Suffolk Preservation Society response to material submitted by Scottish Power Renewables on 15 January 2021 regarding East Anglia 1(N) and East Anglia 2 Off Shore Wind projects.

Landscape and Visual Impact Addendum

Heritage Addendum

Figure: 8g
CHVP3: PROW between Moor Farm and Little Moor Farm

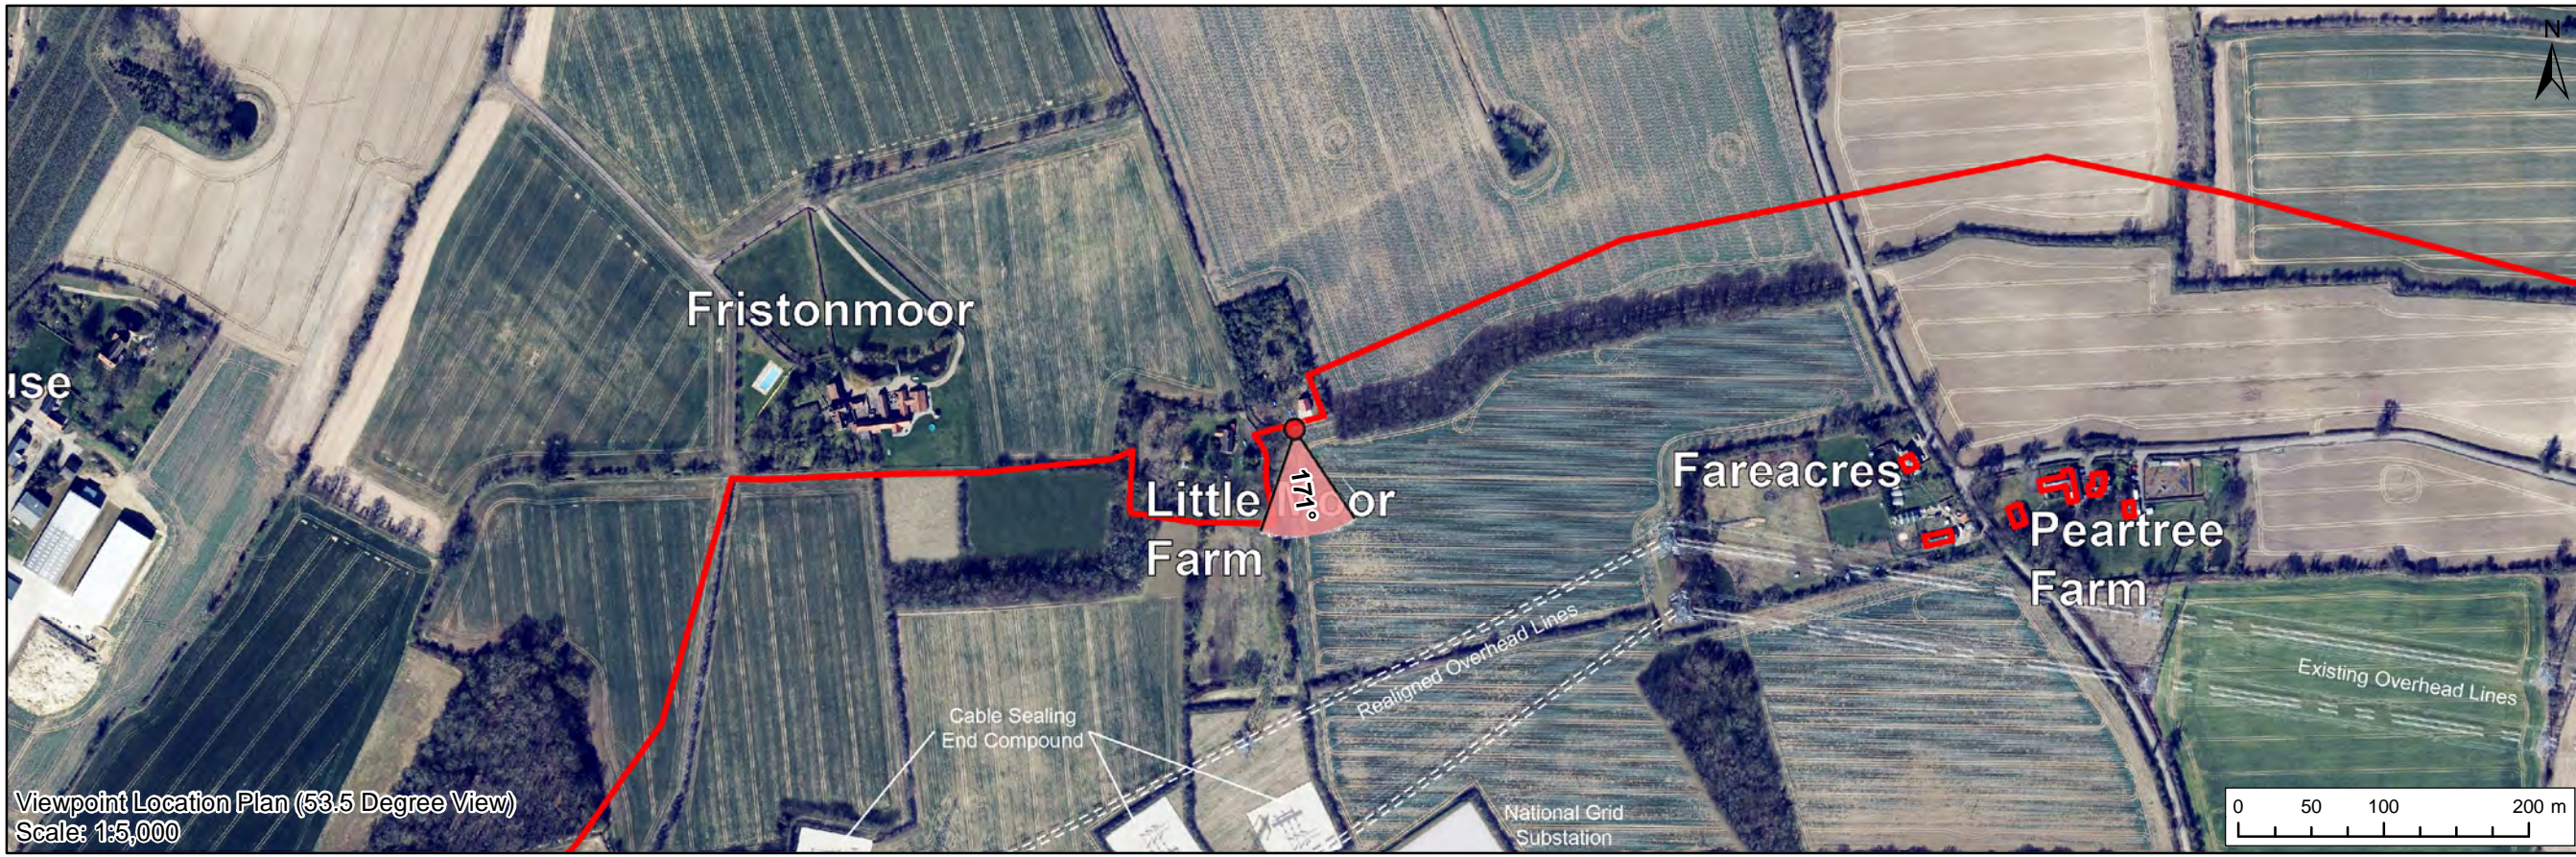
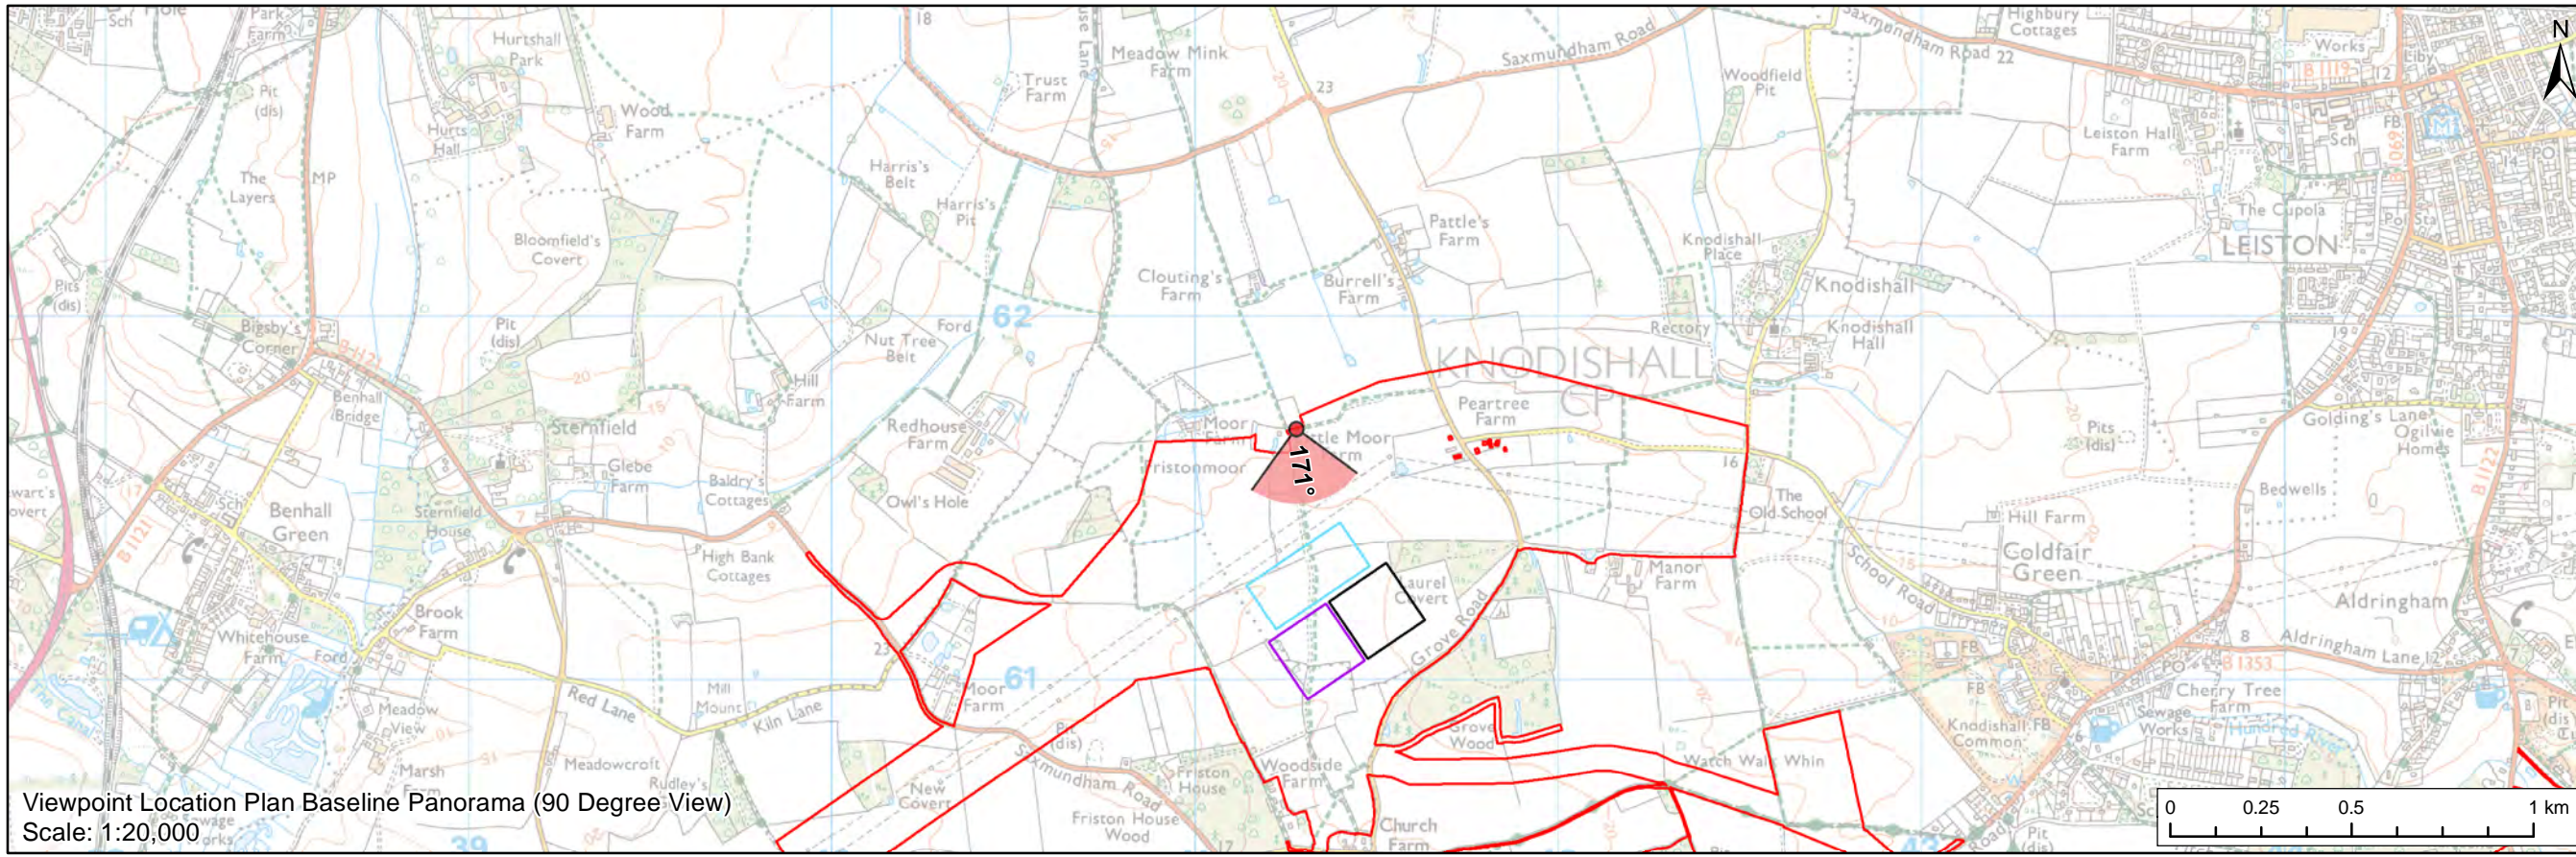
CHVP3 Moor Farm and Little Moor - The visualisation effectively demonstrates the SPS objection that the view from Moor Farm and Little Moor Farm will be lost, together with its relationship to the wider landscape and in particular St Mary's Church. The landscaping proposed merely exacerbates the loss of this visual, historical and cultural link. Despite the reduction in height of some of the structures the gantries of the National Grid and Western substation remain highly prominent in the landscape.

**Figure: 29.37f**  
**Viewpoint 5: Public Right of Way, near Moor Farm**

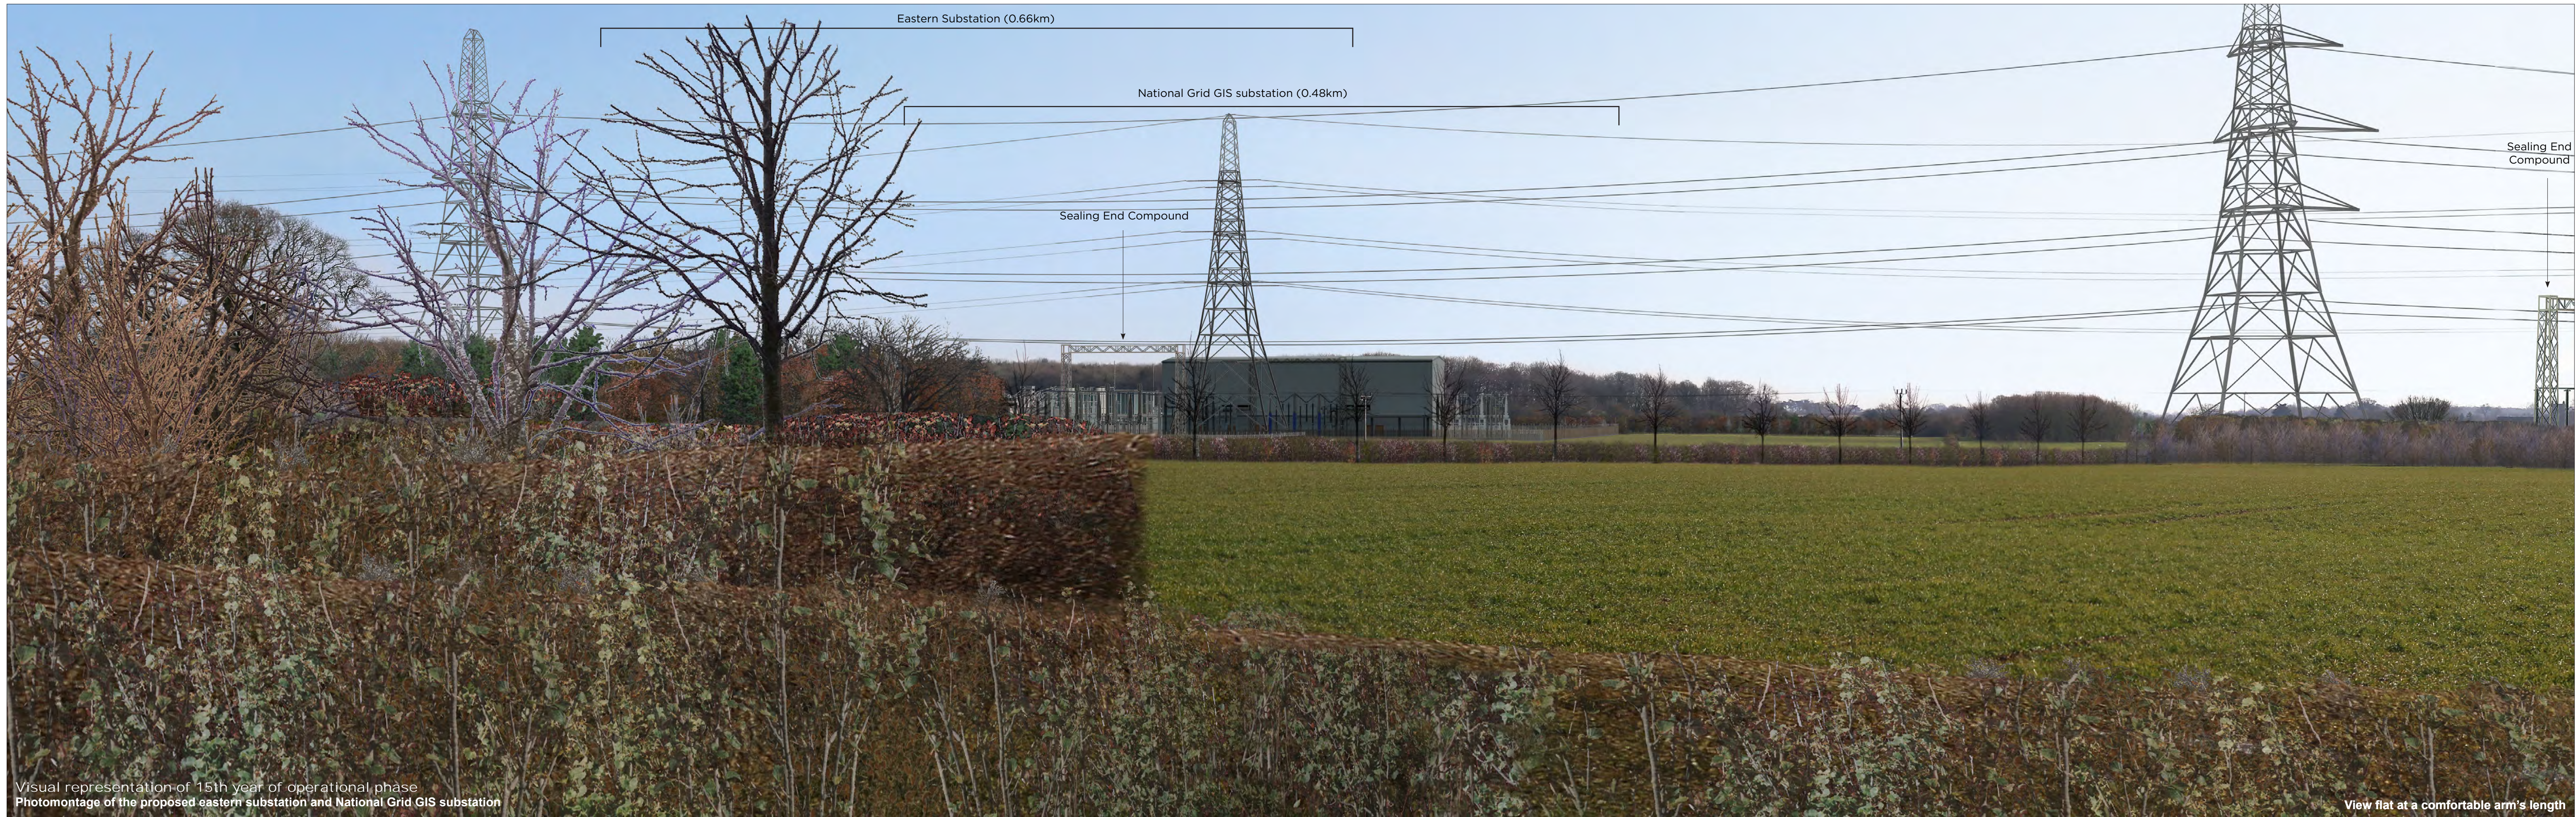
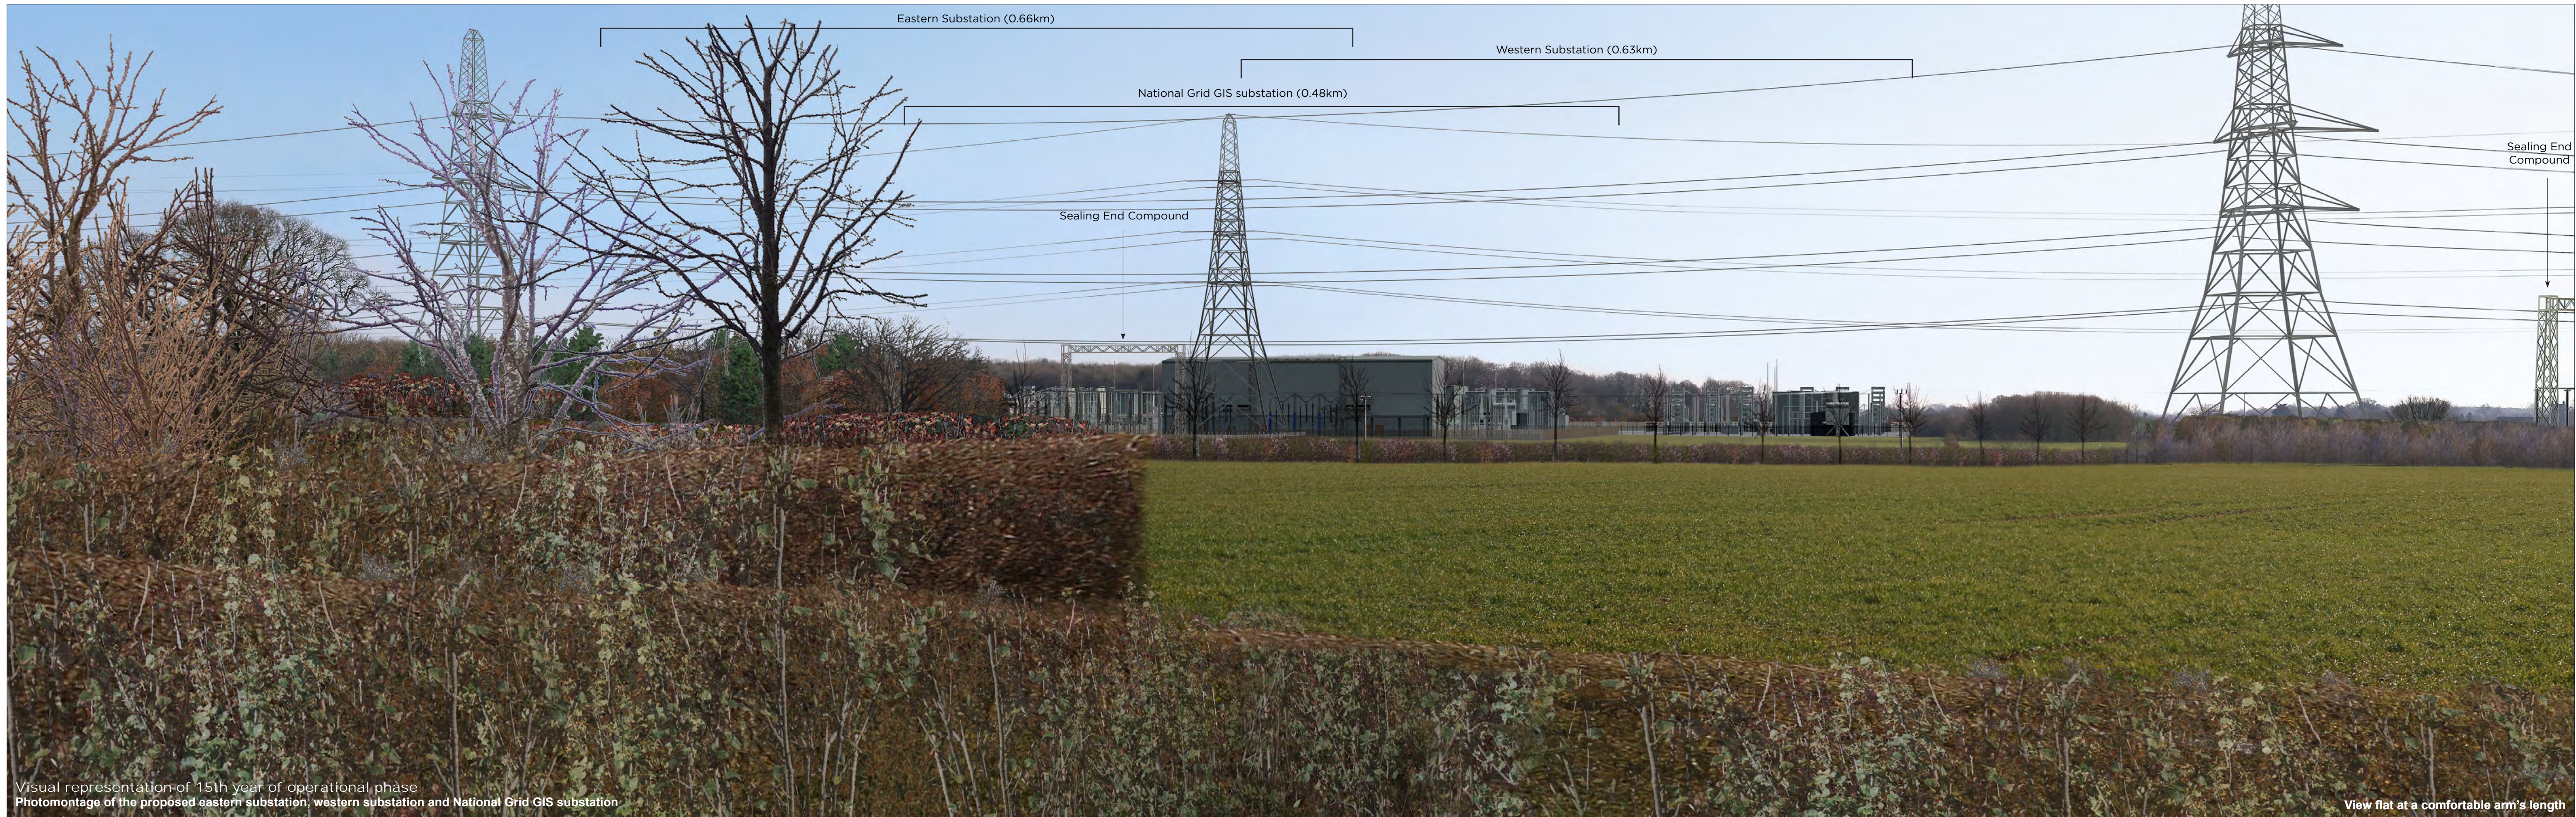
Landscape Viewpoint 5 - The visualisation effectively demonstrates that the views over the wider landscape and in particular towards St Mary's Church, will be lost. The landscaping proposed merely exacerbates the loss of this visual, historical and cultural link. Despite the reduction in height of some of the structures the gantries of the National Grid and Western substation remain highly prominent in the landscape.
